NARWEE PARKLANDS CARE COMMUNITY

SDRP Responding Document

Providing design updates and further clarifications in response to the SDRP meeting held on 12/10/2022

1 SITE ELEVATION - NORTH
1 : 300

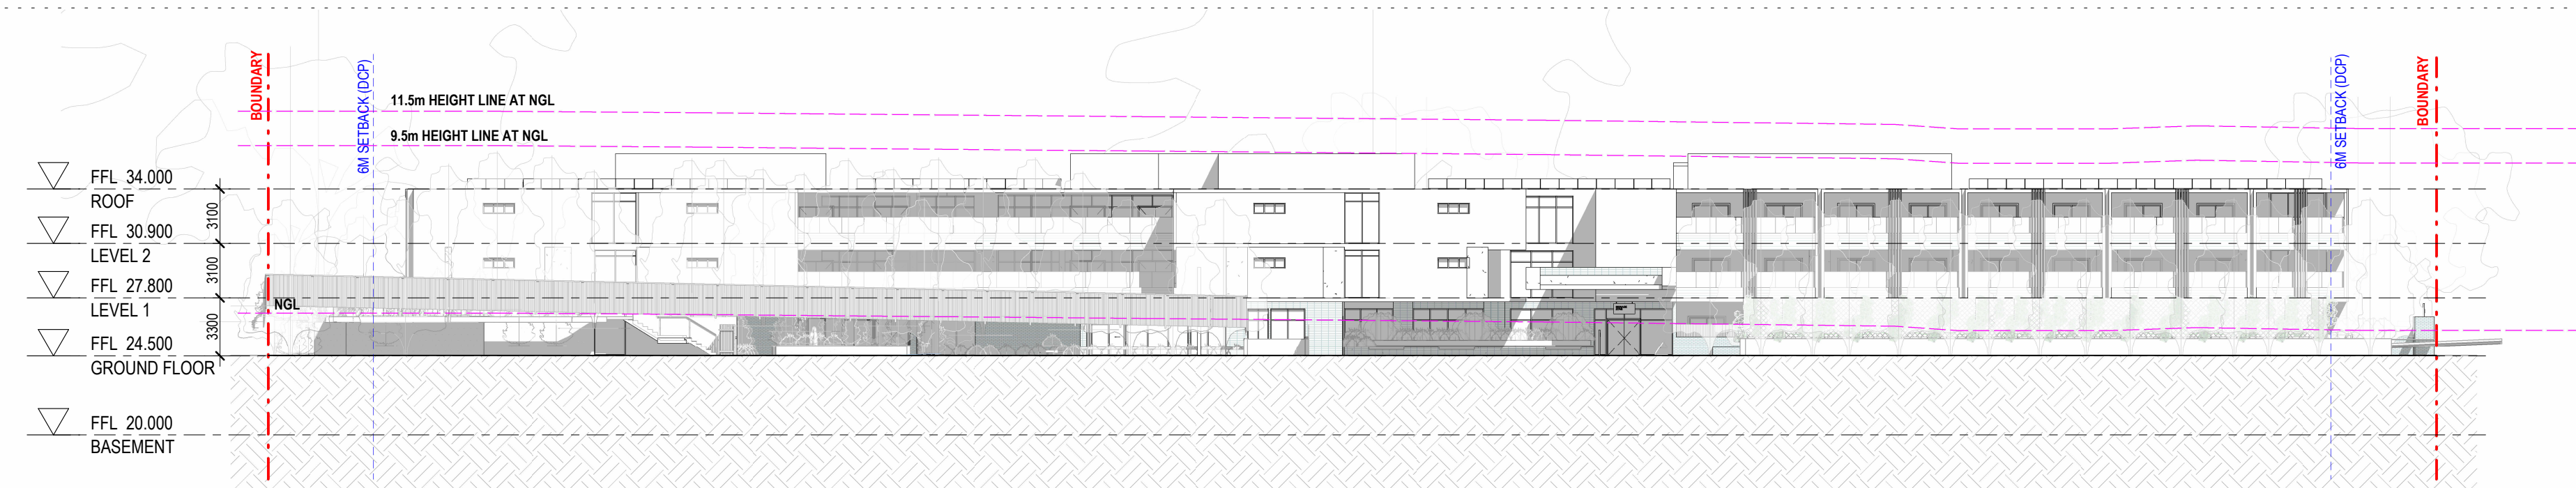
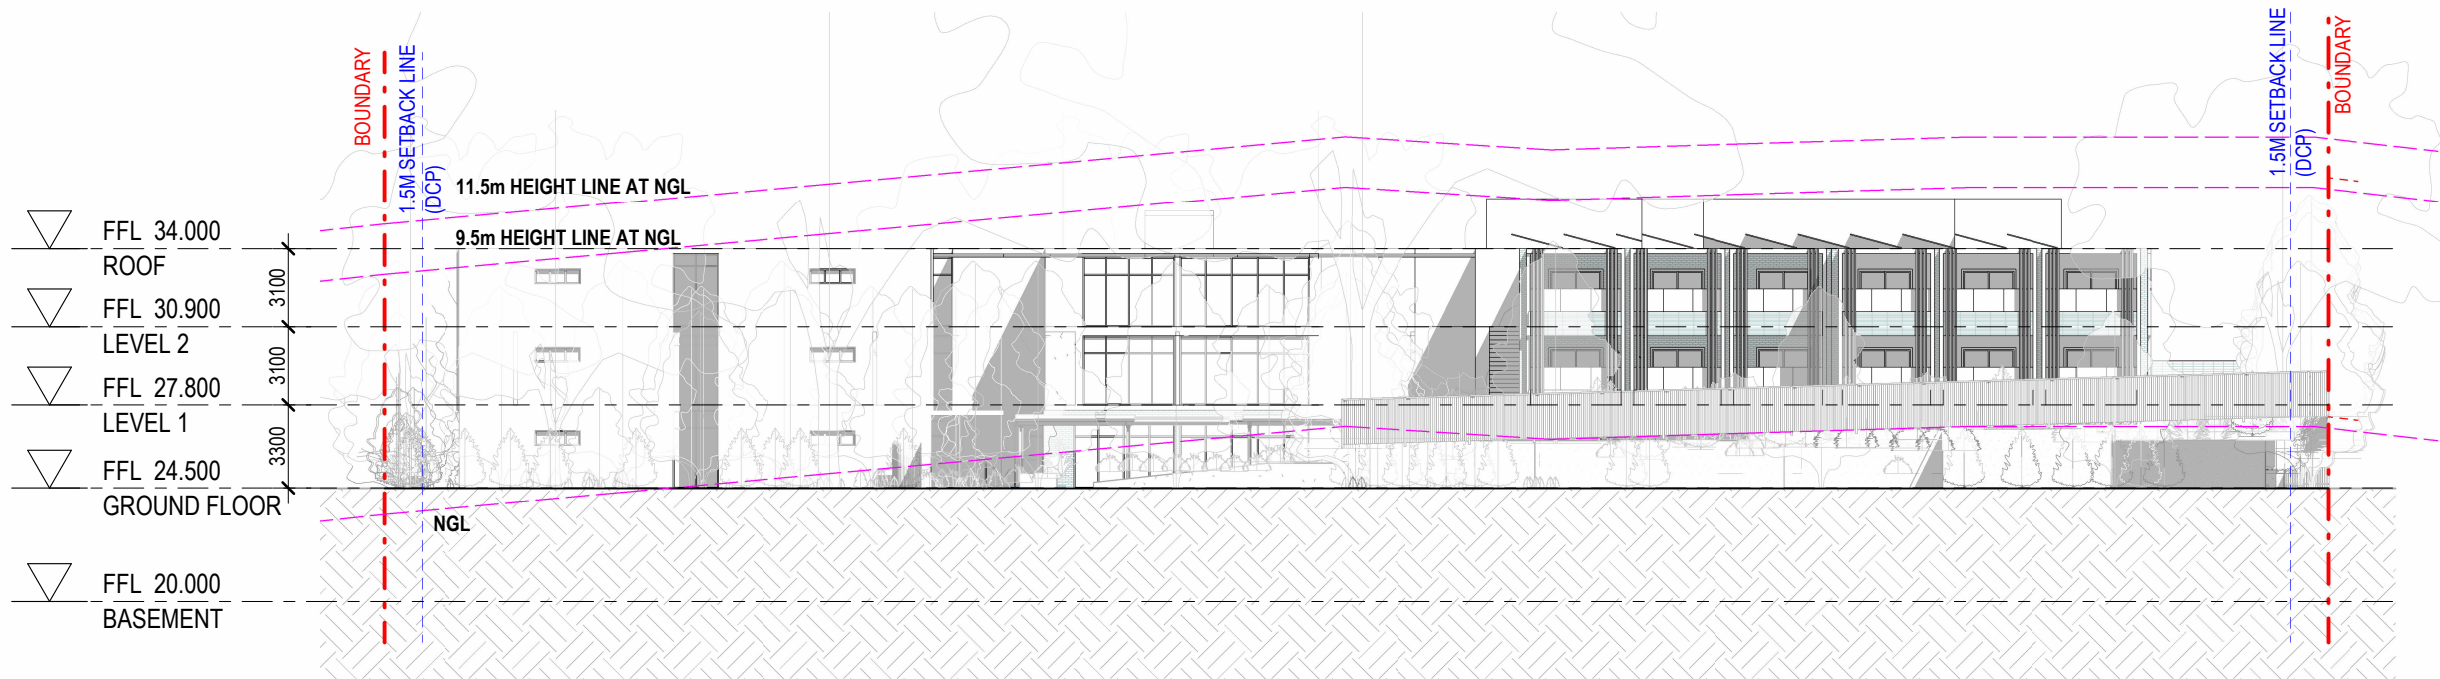
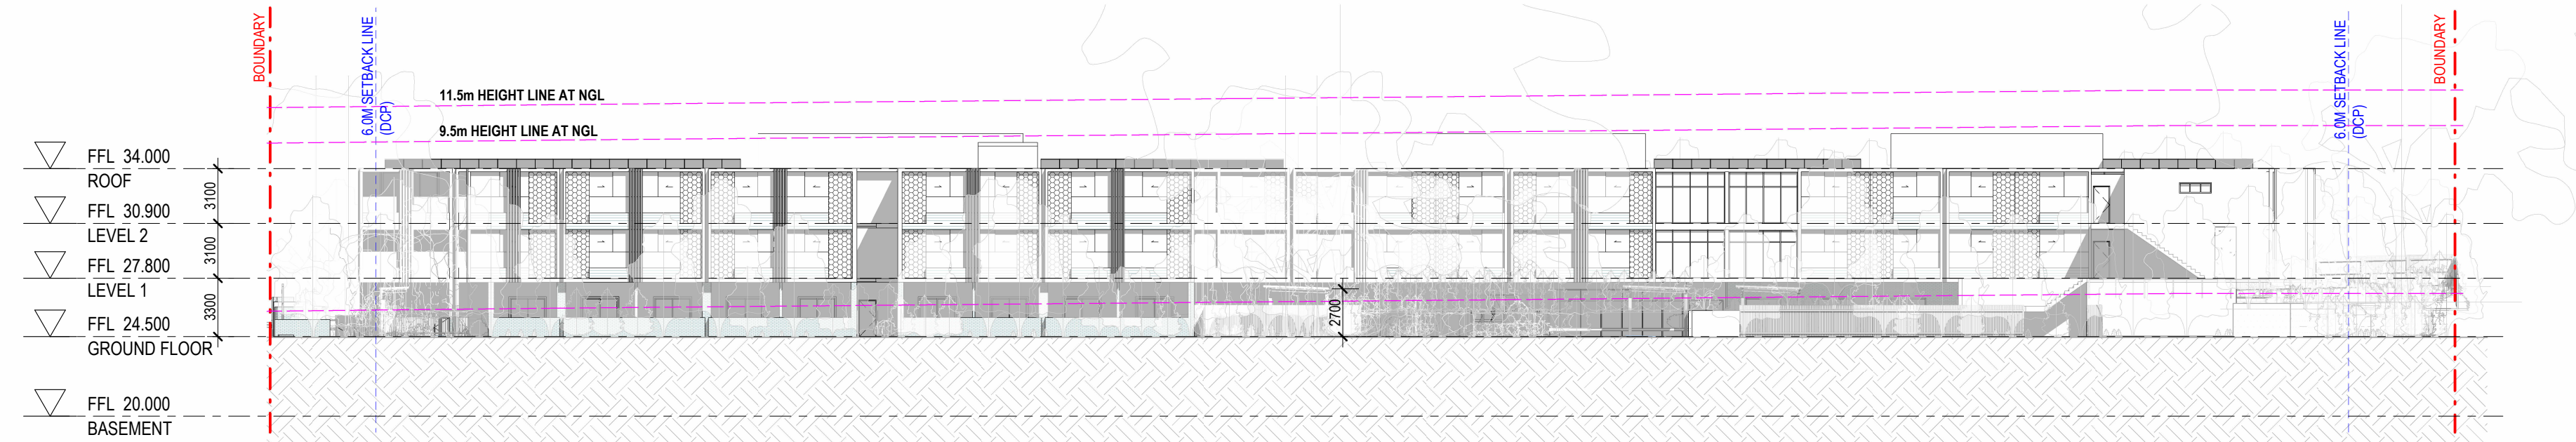
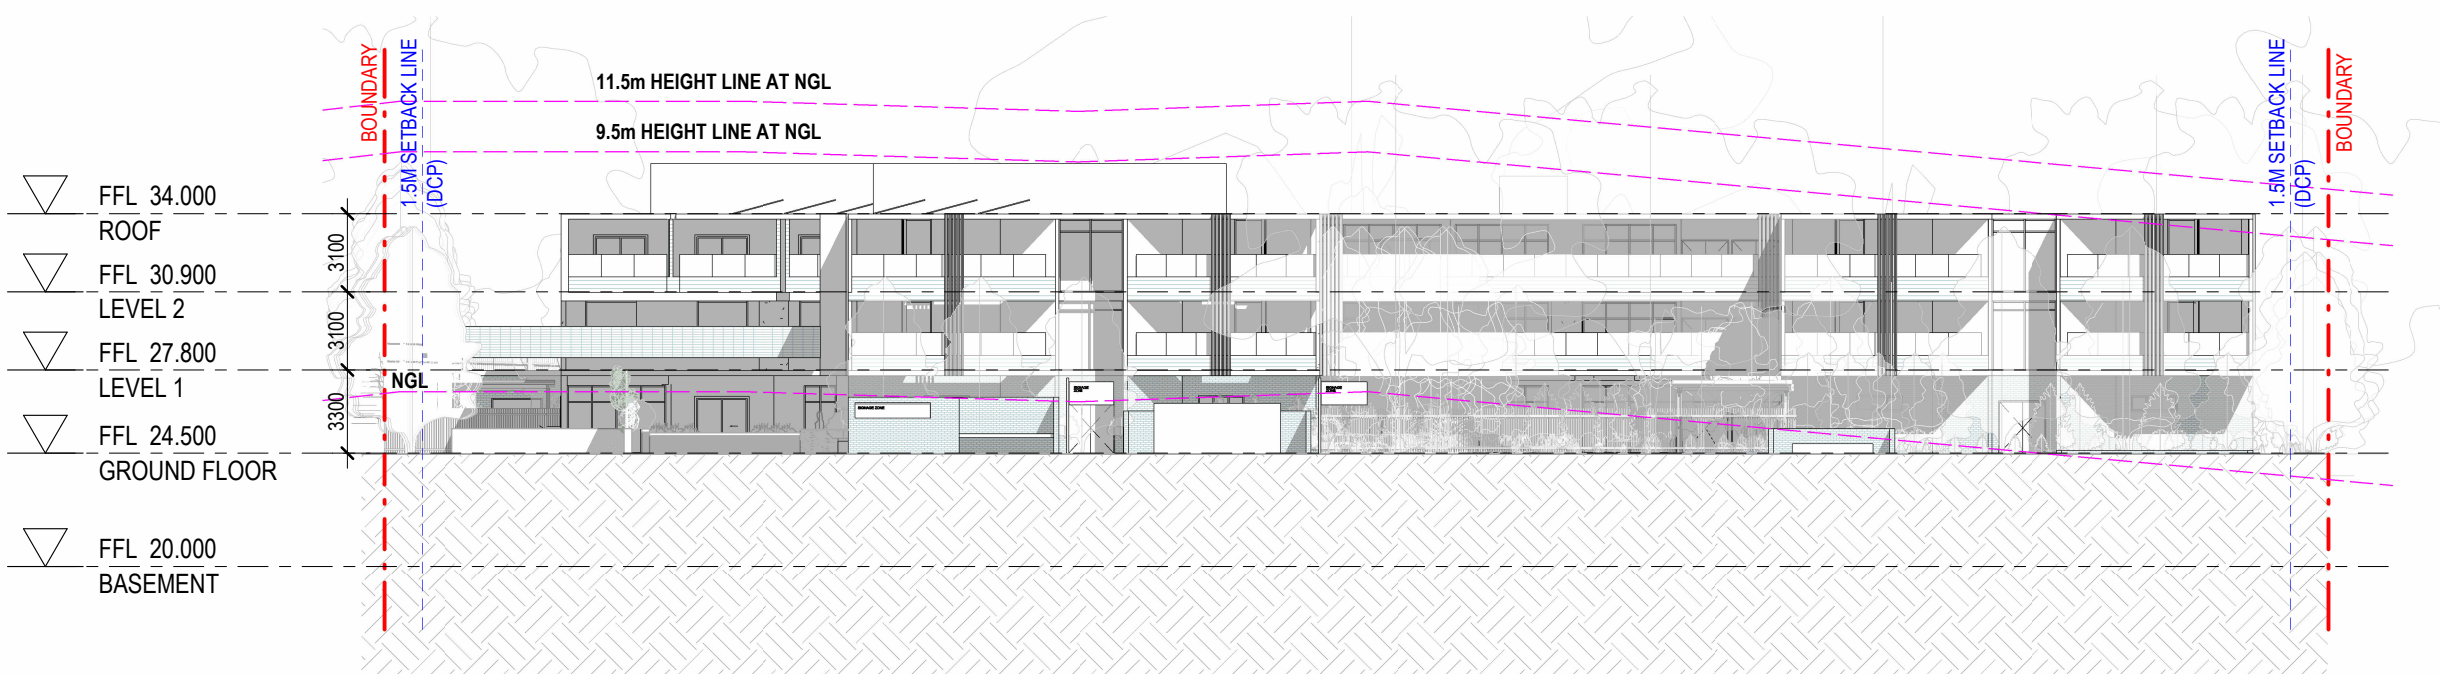
6. The architectural design principles presented at SDRP 1 demonstrated a fine grain articulation of the mass into smaller 'houses'. This has not translated into architectural form. Consider the following:

- a. Vertical separation of the individual blocks by varying storey heights to assist in defining the houses, rather than a continuous three storey monolithic form.

- b. Articulation of the roof forms to reference the surrounding pitched roof house typology.
7. The site has four unique urban situations. Contextualise each façade and develop more individually site responsive solutions.

6. a. The fine grain articulation of mass is explored through 'clusters' of rooms, in lieu of storey heights for not to breach permissible heights. The residential clusters have been broken into smaller elements to articulate and reflect the existing local developments. Alternating louvres and screens up the façade will soften the regularity of the grid.
 - b. Articulation of the roof is addressed through variation of façade / roof edge junction in lieu of roof forms itself. The variation of façade 'clusters' roof edge details subtly articulate the elevations.
7. Each façade treatment responds to the site and its four unique urban situations.

The Northern façade has been set back to allow for more privacy for the residents and neighbouring buildings. At Ground Level, the façade is predominantly tiled with face-brick to ground the building form. The set-back also enhance private open space from boundary.

Perforated screens and sliding panels have been introduced along the Southern elevations. The proposed screenings also address outlook onto motorway and adjacent public park.

The Western courtyard allows for the bedrooms windows to face away from Karne Street North. The balconies and terraces are more open to enable residents to enjoy the external area.

The Eastern façade has also been set back from the boundary fence line, to prevent neighbouring buildings from being overlooked. Vertical louvres have been introduced to upper levels to provide screenings.
8. Perforated screens, louvres and sliding windows have been incorporated into the South facing facades. This will enclose and protect the balconies from prevailing wind and increase privacy from the park.
9. Planter hedges have been proposed to screen off resident rooms at Ground Level, in particular to rooms adjacent to entry driveway and Western communal courtyard.
10. Proposed staff amenities remain in Basement to suit the operational needs of Opal HealthCare. Large skylight has been proposed to Staff Room and staff can access to on grade outdoor space for breakout.

1 DEEP SOIL INCLUDING BIODIVERISTY
1 : 600

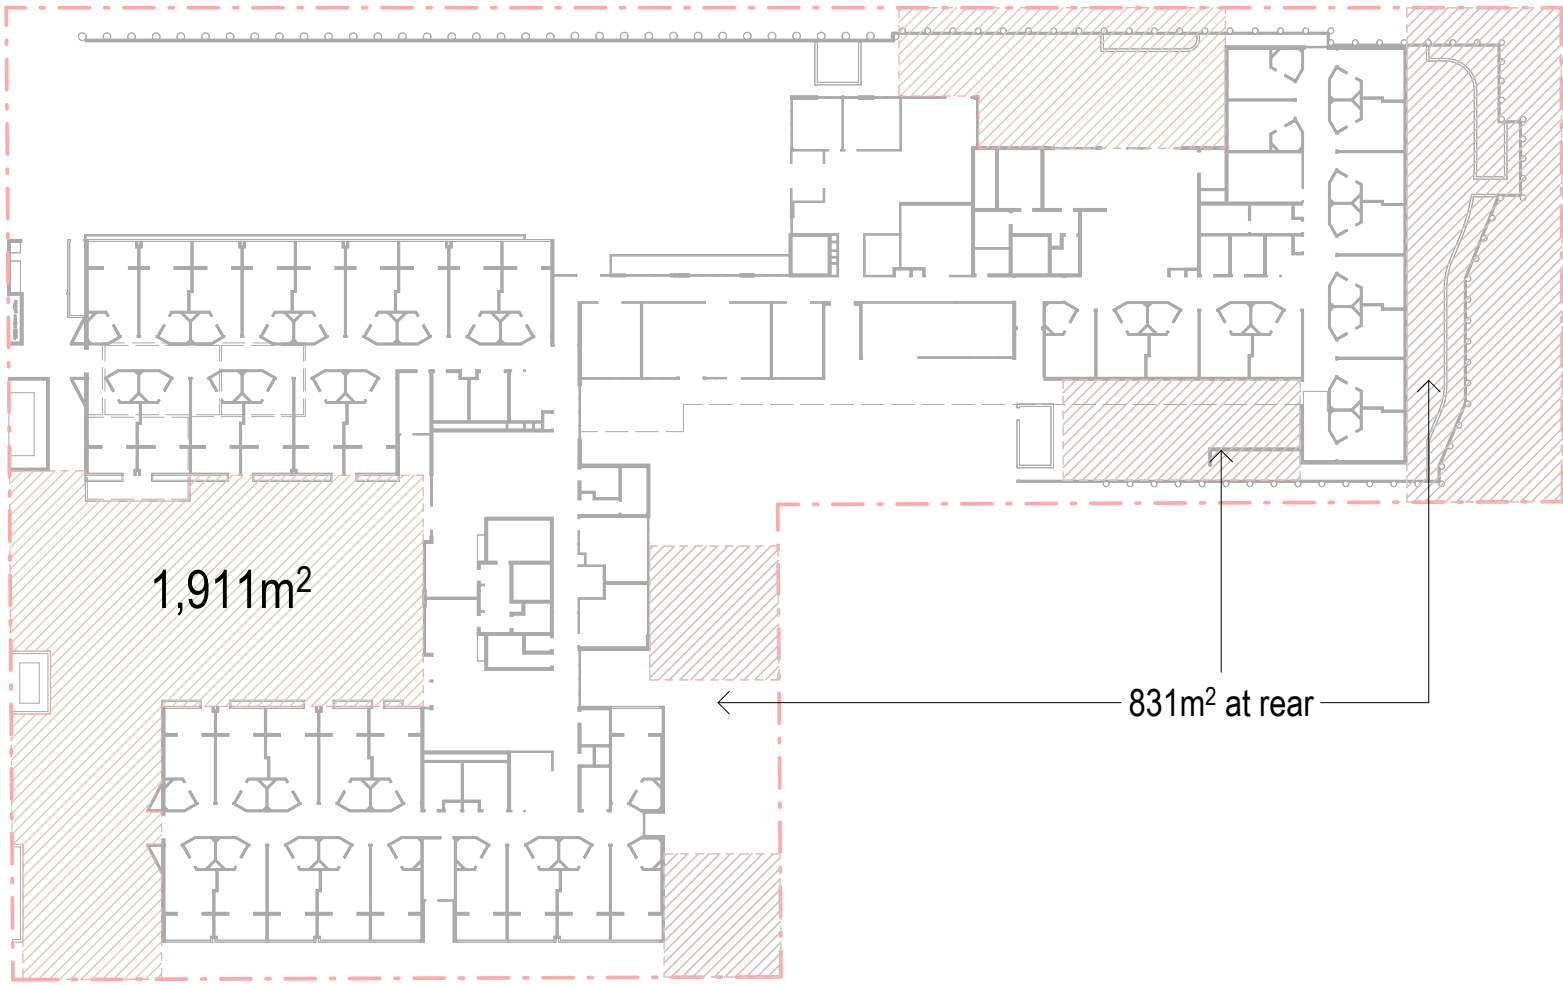
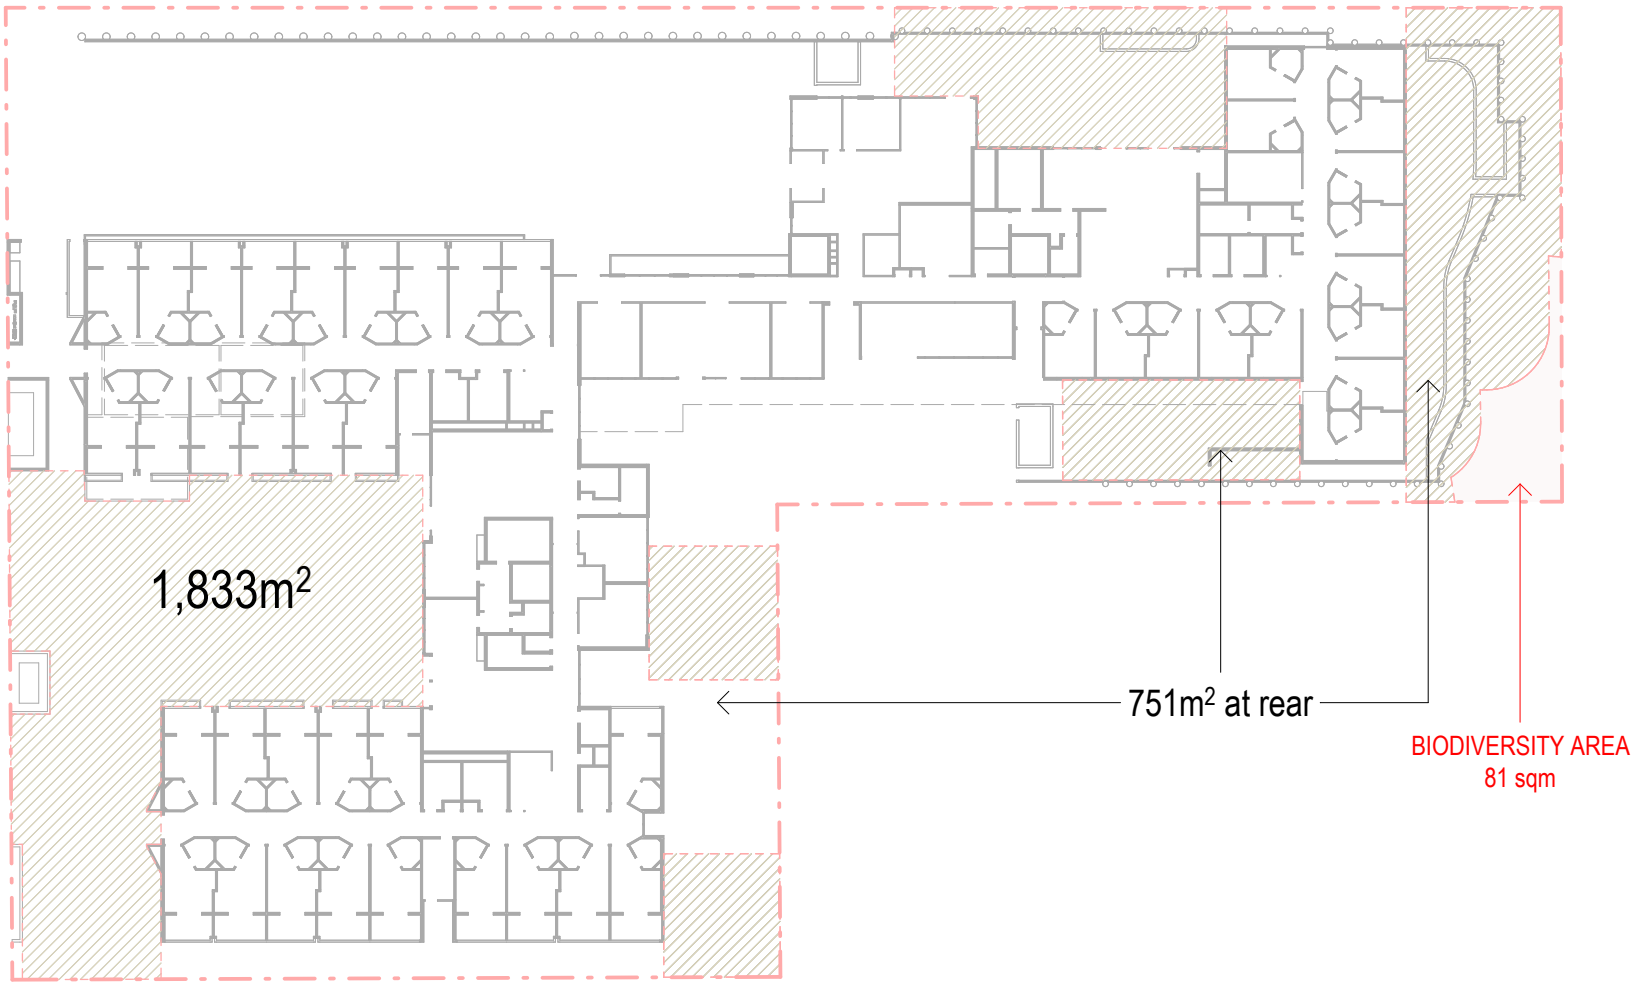
3. The main site entry is dominated by driveways and ramps. Reconsider the north-western interface to improve the arrival experience:
 - a. Investigate the potential to switch the carpark ramp with the ground floor driveway, increasing deep soil provision.
 - b. Increase the landscape buffer to the north of the driveway, to enhance the separation between the neighbouring dwellings and provide a better outlook for the ground floor apartments.
 - c. Incorporate soft landscaping through to the port cochere to reduce the extent of hard pavement.
4. Review the proximity of the elevated protected biodiversity zone, to the eastern ground floor apartment, to ensure the apartment receives sufficient sunlight.
5. Ensure deep soil zones have minimum dimensions of 6m (Housing SEPP, Section 107).

4. The Eastern facade has been further set back from boundary fence line to allow greater depth for sunlight to cast into the resident rooms.
5. Confirming deep soil zones calculation are taken from min. 6m dimensions.
